From: Anita Gardner
Sent: 11 July 2018 16:54
To: Planning.Responses
Subject: FW: M/64/18/DOC172 Elmer Road

Please treat as additional information from agent relating to condition 8

172 Elmer Road	5 April 2018	KS	1
199	1735	Chkd: -	Rev. B

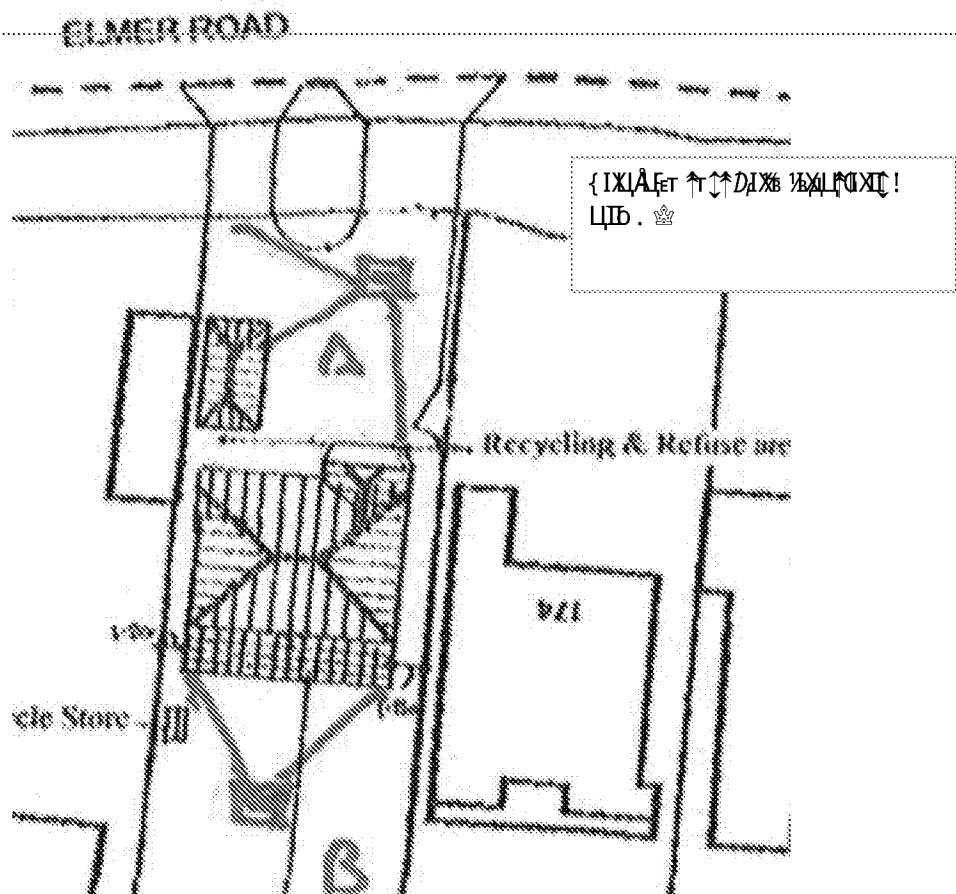
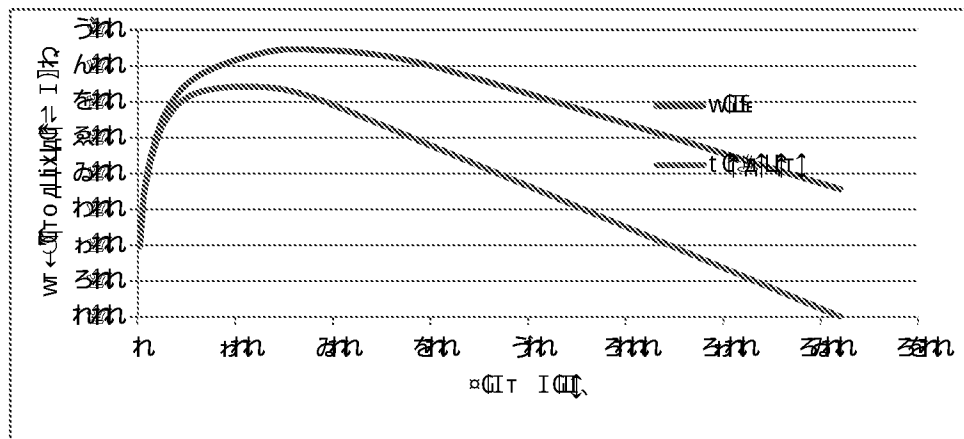
It should also be noted that the lowest recorded infiltration rate should be used, not the average. I.e. please use $6.07 \times 10^{-6} \text{ms}^{-1}$ – Test hole A has the lowest infiltration level. This result has been used for the new calcs.

Project:	172 Elmer Road	Date:	July 2018	Made by:	KS	Sheet No.	1
CALCULATION SHEET		Job No.	1735	Chkd:	-	Rev.	C

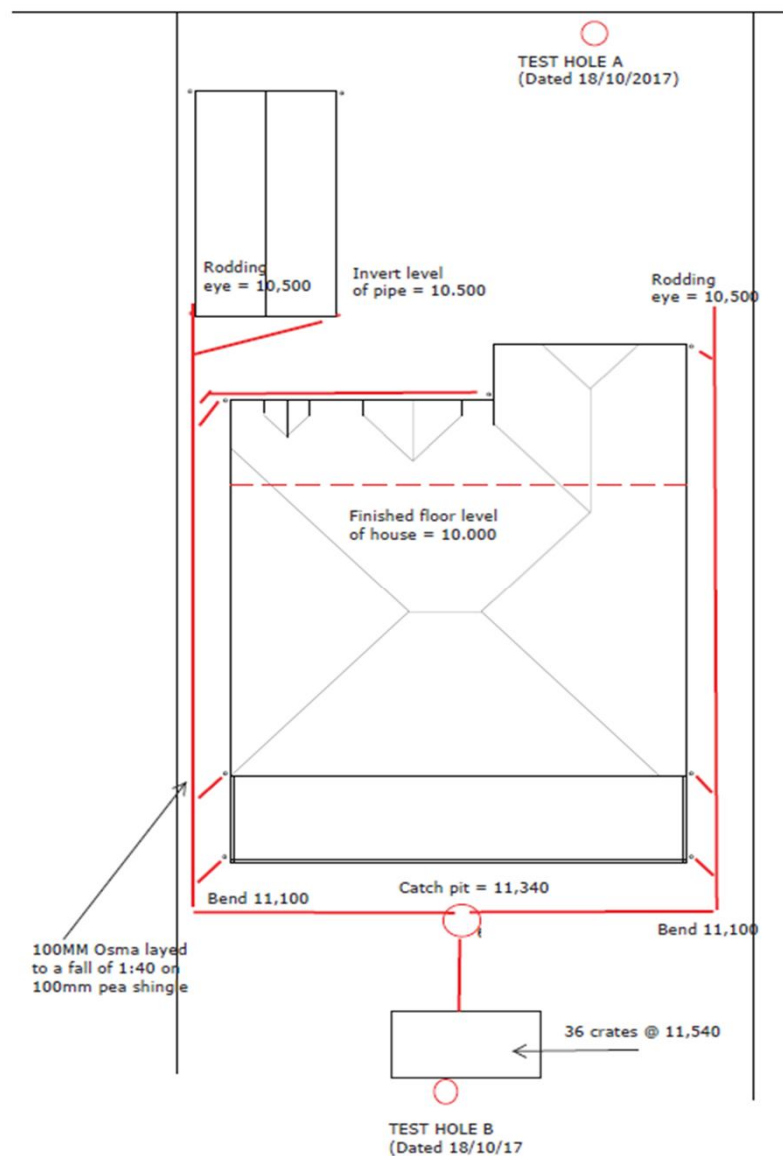
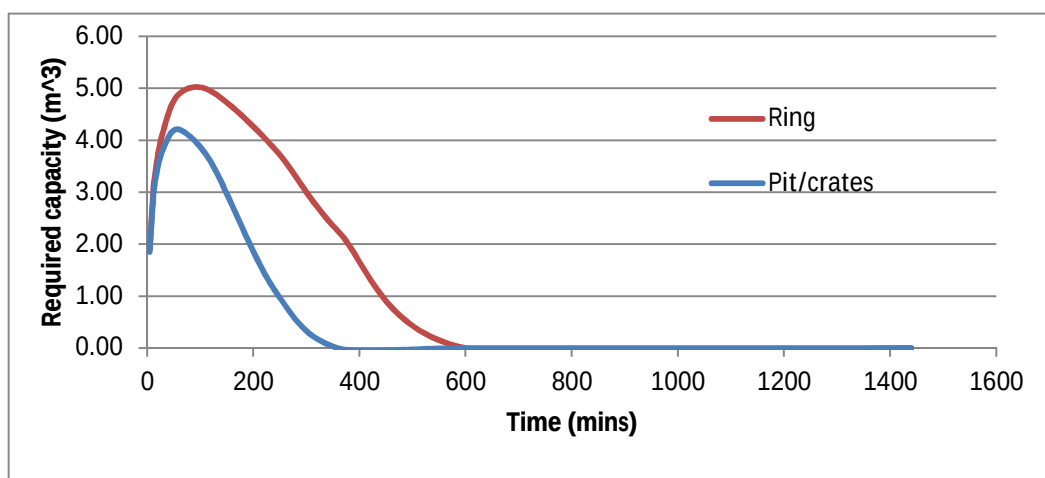
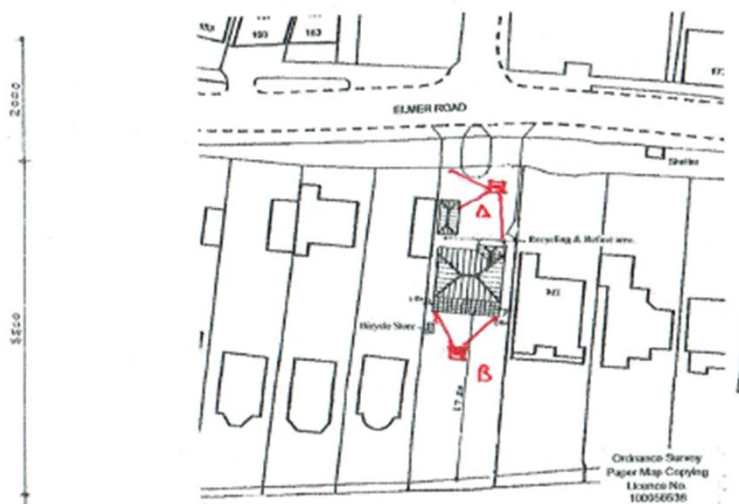
- I am a little confused as to how the infiltration rates have changed between submissions. In the previous submission the lowest rate was $6.07 \times 10^{-6} \text{ms}^{-1}$. Now it has changed to $5.46 \times 10^{-5} \text{ms}^{-1}$. Please can the applicant explain this discrepancy?
The original infiltration rate was incorrectly calculated and based on a different field test. The actual test was a percolation test with the results reported in Vp (mm/sec), the test method and the derivation of infiltration rate is detailed in the calculation together with the test results. And the worst infiltration value has been used which is very conservative as the infiltration rate measured at the location of the soakaway is an order of magnitude greater.

- Please ensure all infiltration structures are at least 5m from buildings.
We have now re-designed the drainage to account for all four above points. Please see attached.
